From: Laura Gibbons
Sent: 05 July 2018 12:49
To: Planning.Responses
Subject: RE: Planning Consultation on AL/60/18/DOC

Engineers Comments Relating to Condition 4- Surface Water Drainage

APPLICATION **AL/60/18/DOC**

Registered: 04-JUN-18
Site Address: Sack Lane Dairy Sack Lane Aldingbourne PO22 9PD
Description of Works: Application for approval of details reserved by conditions imposed under planning permission AL/58/17/PL relating to condition No. 4 (Surface water drainage scheme), 5 (Contamination), 6 (Hard and Soft landscaping), 7 (materials), 8 (details of new screen walls and fences), 11 (Secure & covered bicycle stores), 12 (details of storage of waste and recycling) & 17 (external lighting)

NOTES:
All dimensions must be checked on site and not scaled from this drawing.

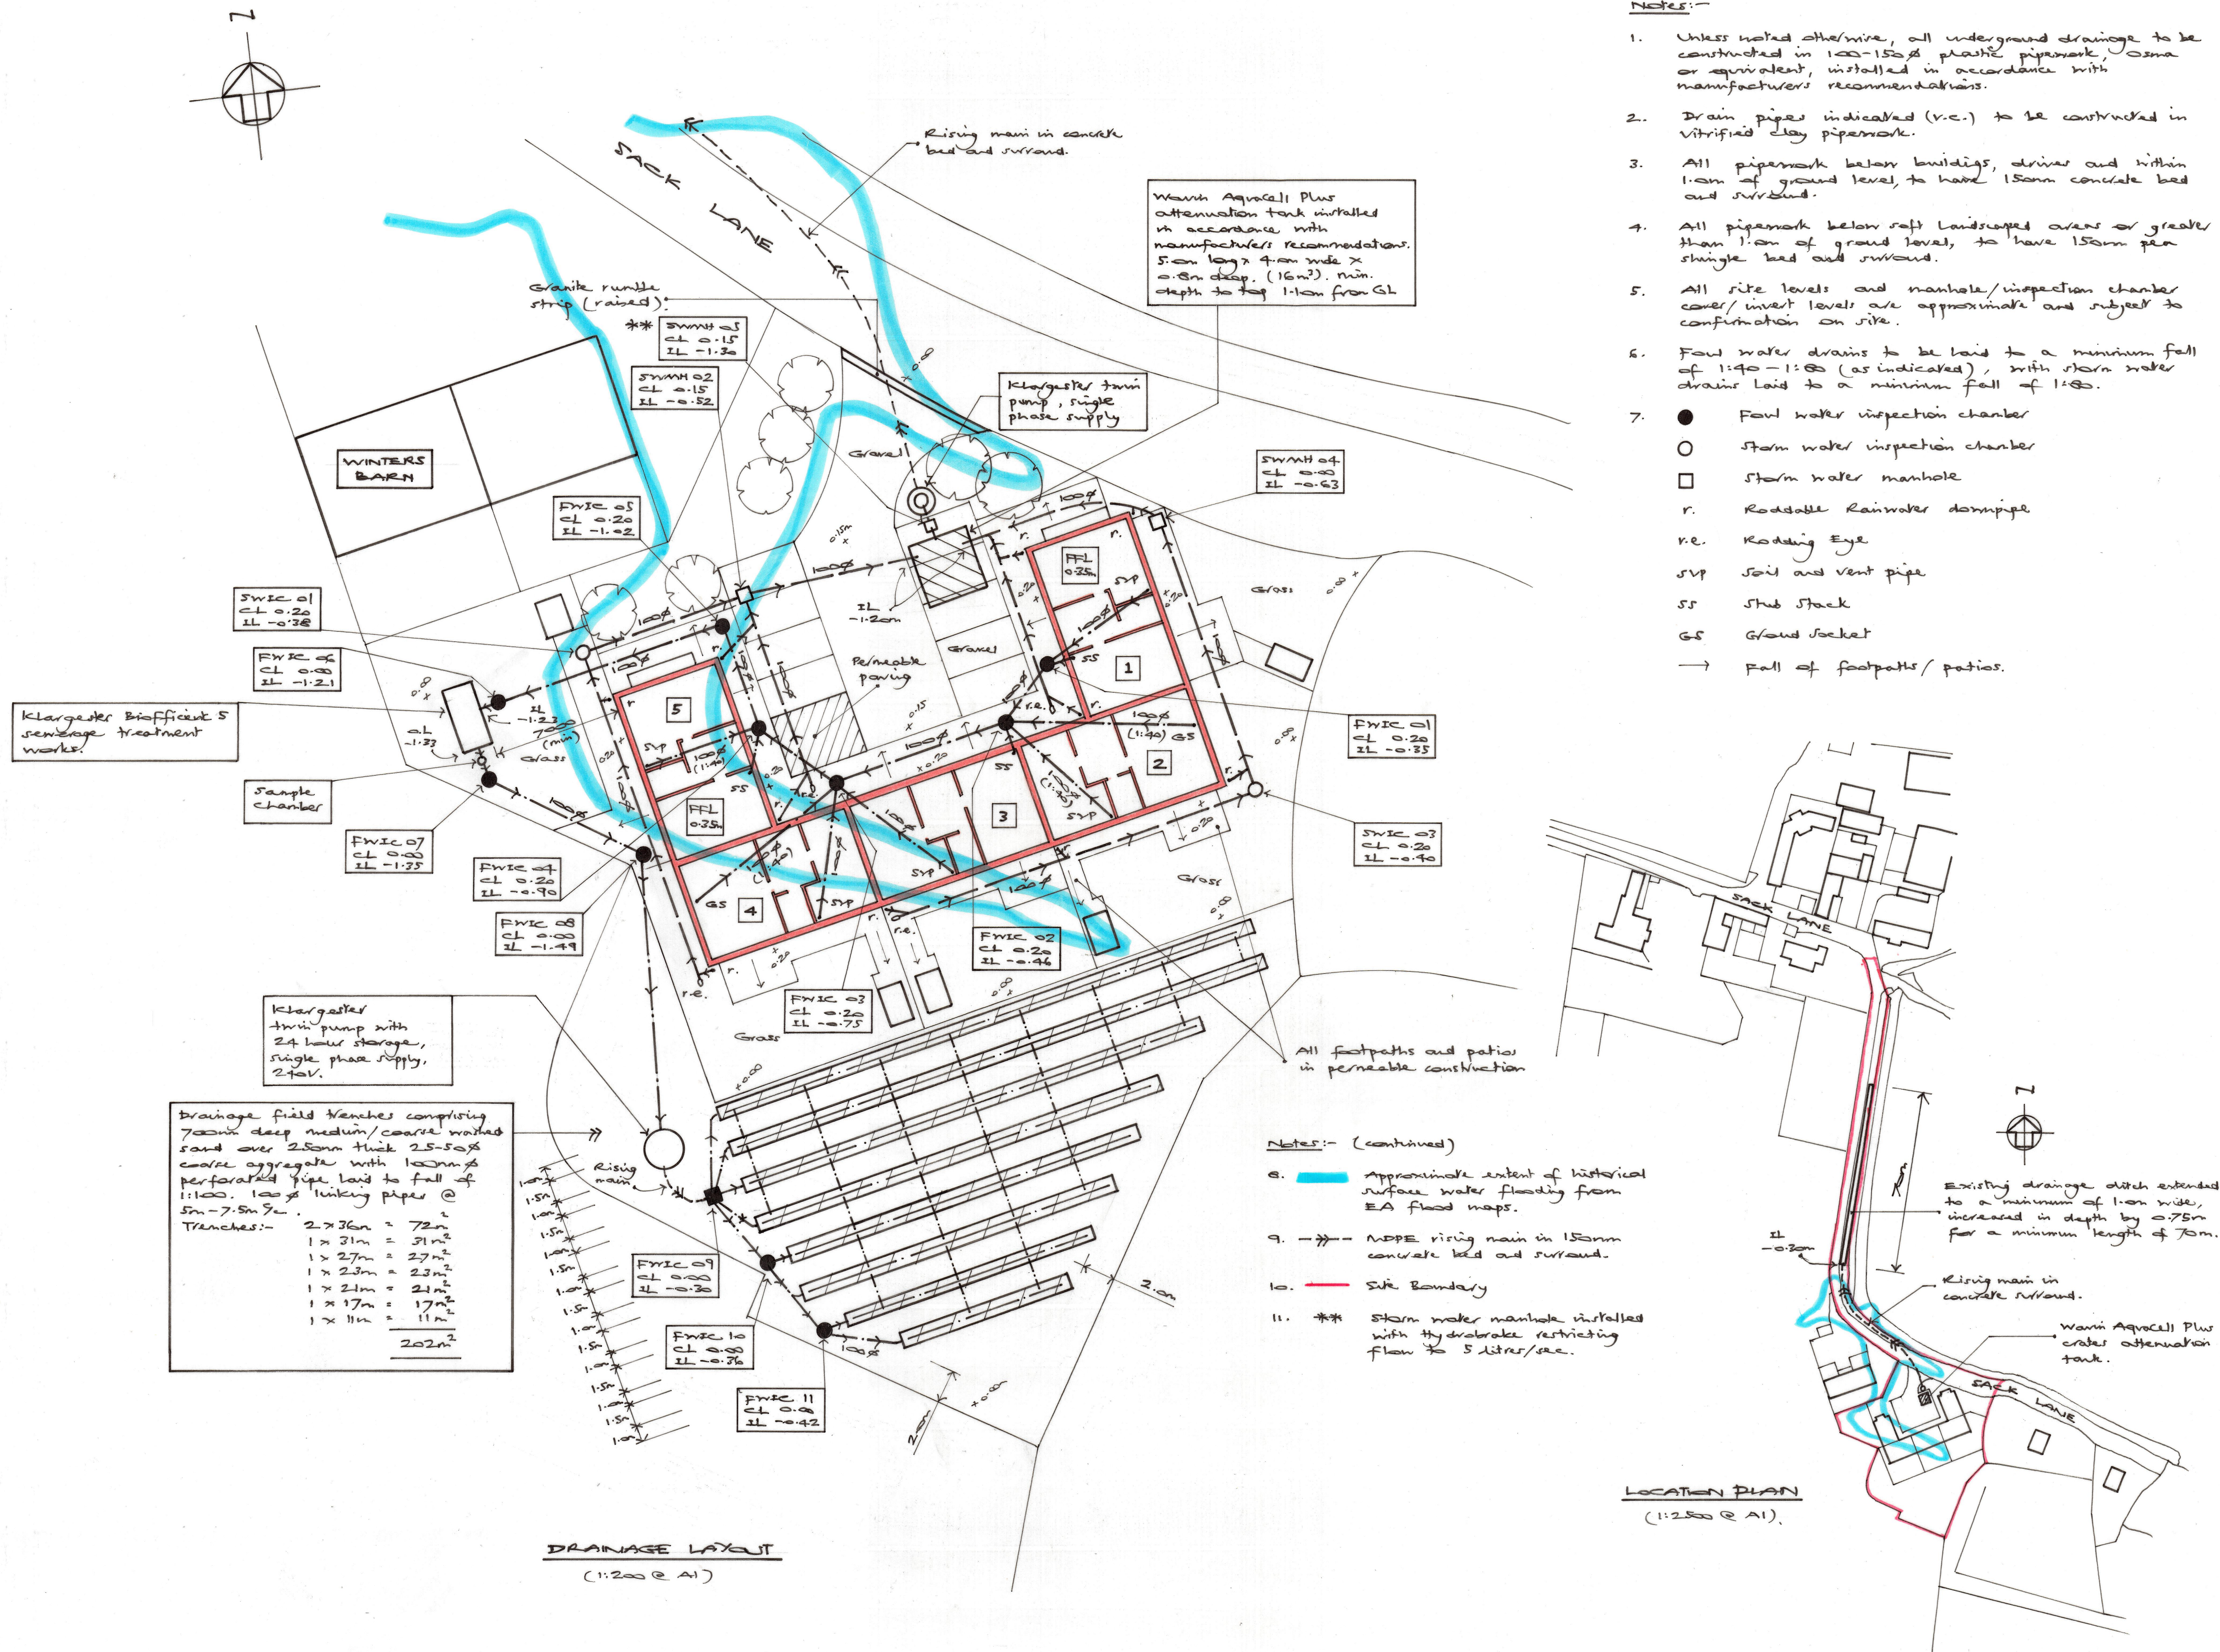
Surface water up to the 1 in 100 year plus climate change event needs to be contained on site. Discharging into the ditch at an uncontrolled rate is inappropriate as this will pass these flows on beyond the development boundary.

Please re-design the drainage scheme.

Typical Gravel Surfaced Permeable Paving
Scale 1:20

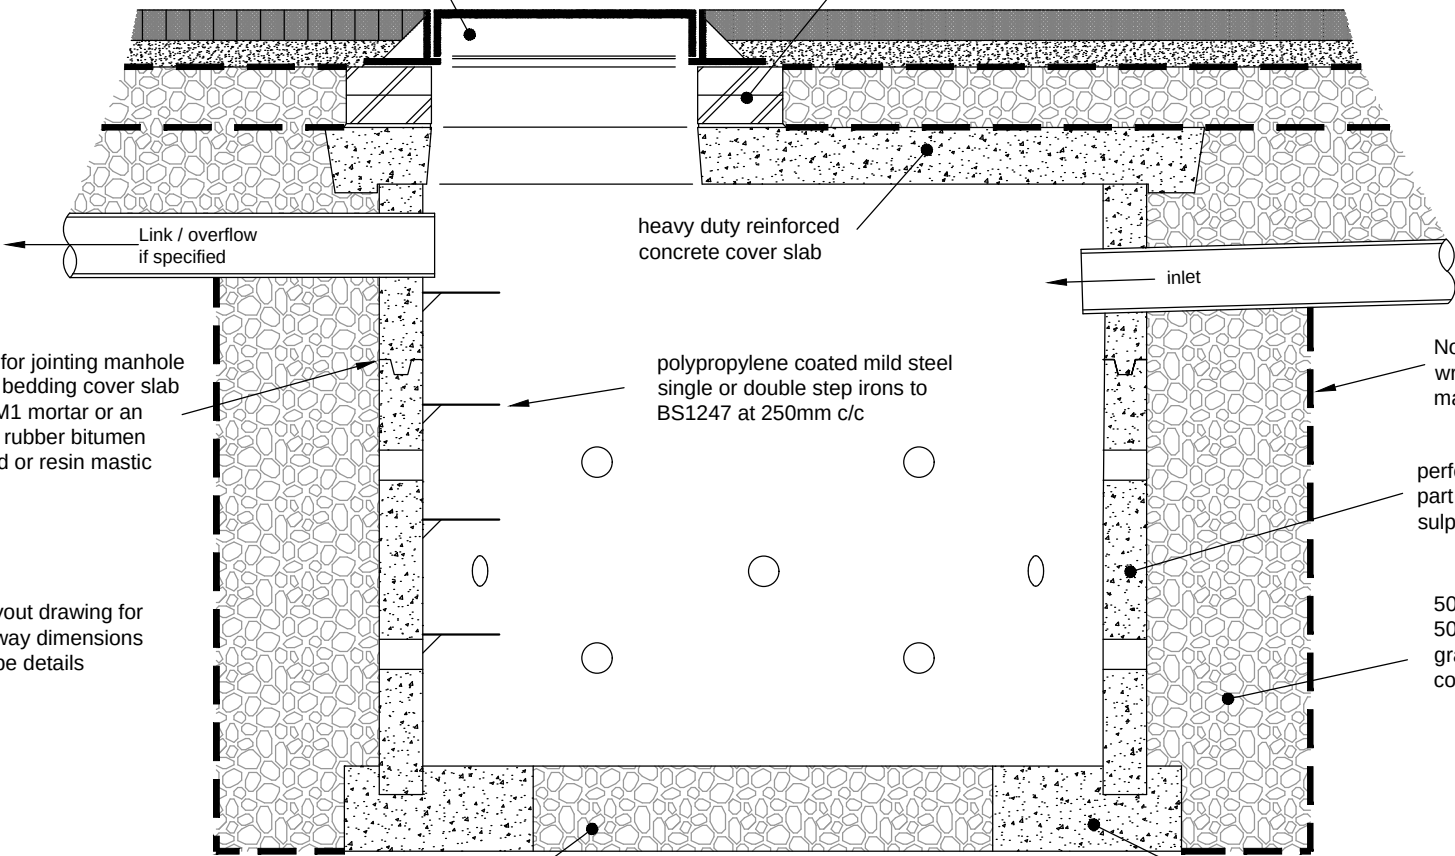
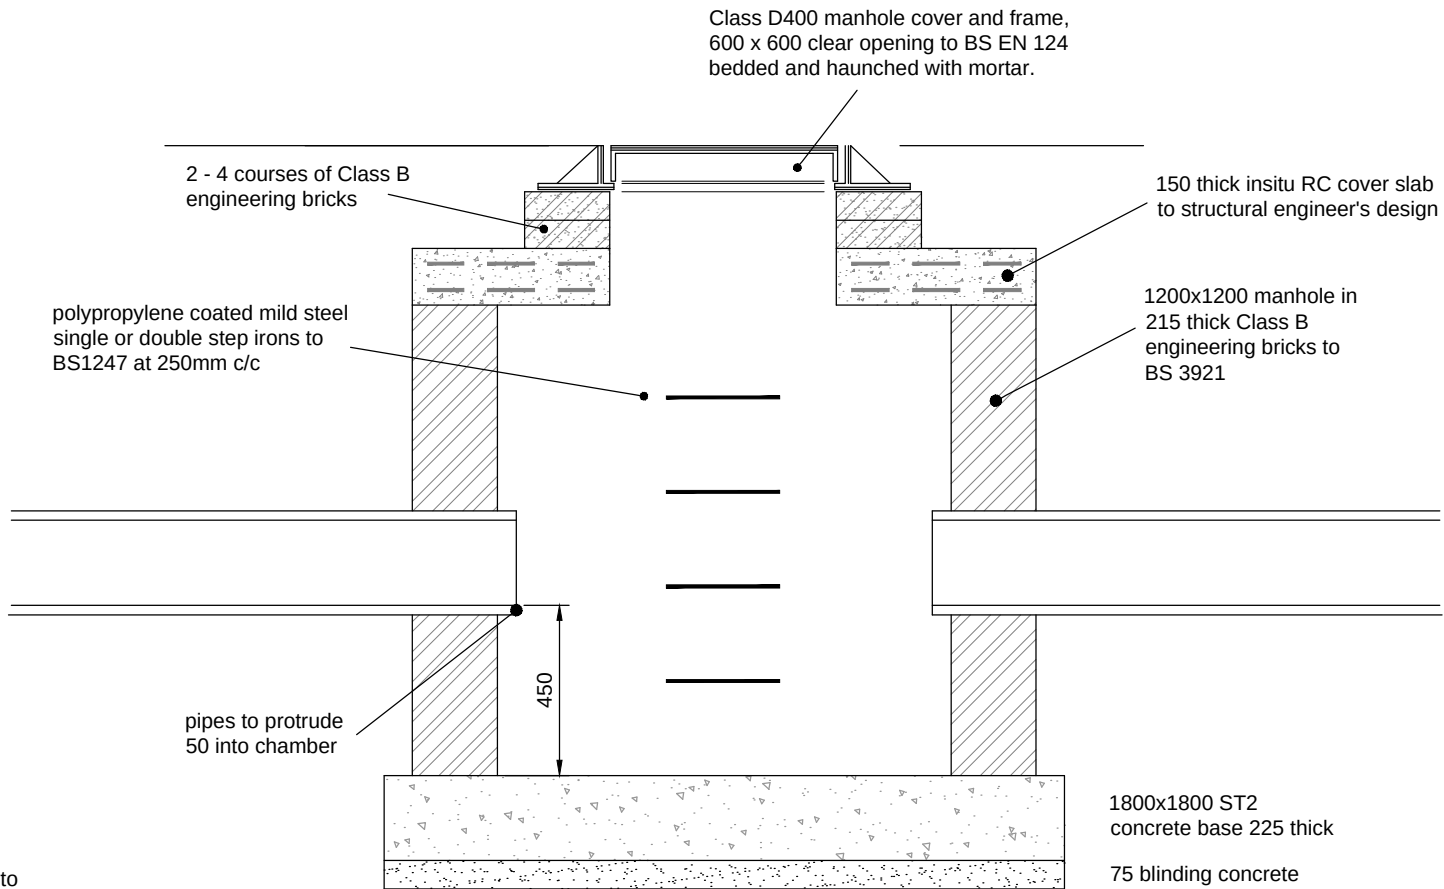
Construction details need to be provided for the permeable paving.
